SITE PLAN DRAWING CHECKLIST

PROJECT NAME: KOEPPEN ADDITION
SUBMITTAL DATE: 10/15/18
SUBMITTED BY: CRIS COTHIER
SUBMITTAL REVIEWED BY: _____

ite-Plot Plan - Mr. & Mrs. Jerry Koepfen - 6035 Sioux Trail
(1206 SF)
Remove 16' x 25' Deck - New 16' x 25' Addition - New 12' x 29' Deck
Remove Old Cess Pool - New Septic System Scale 1/8" = 1'

Site-Plat Plan - Mr. & Mrs. Terry Koepfen - 6035 Sioux Falls (1206 SF)

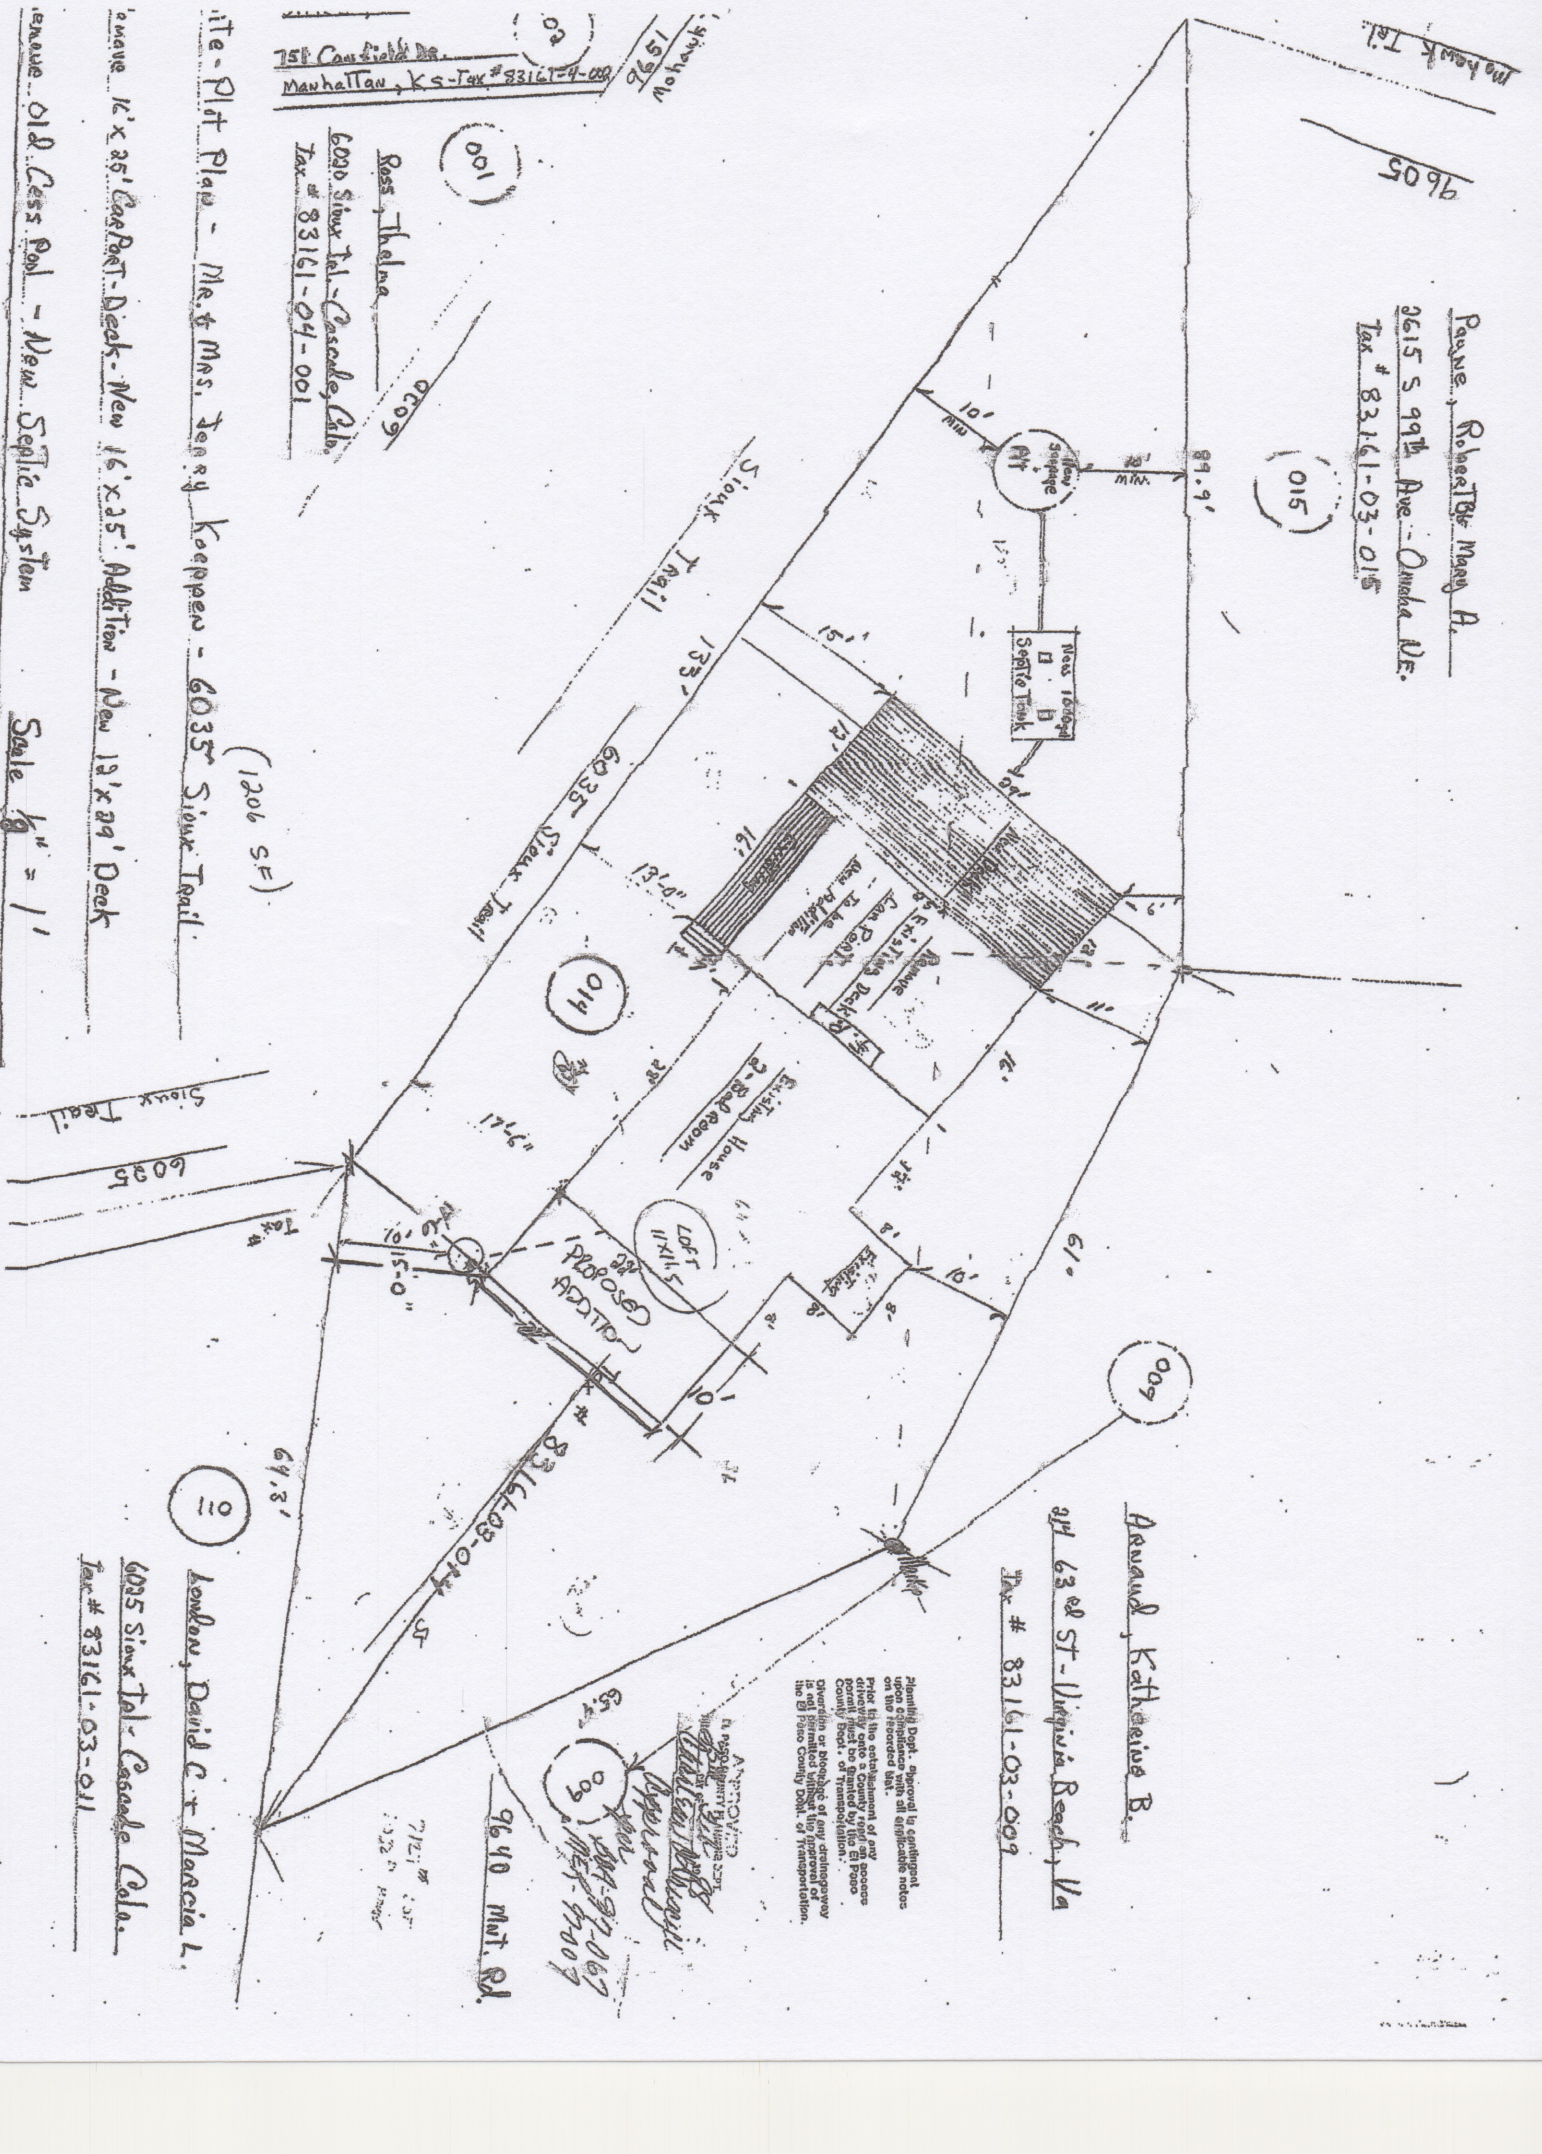
The property should be surveyed then resubmitted, the drawing does not match what the assessor shows as the legal lot. Cannot legally depict and request without proper boundary lines.
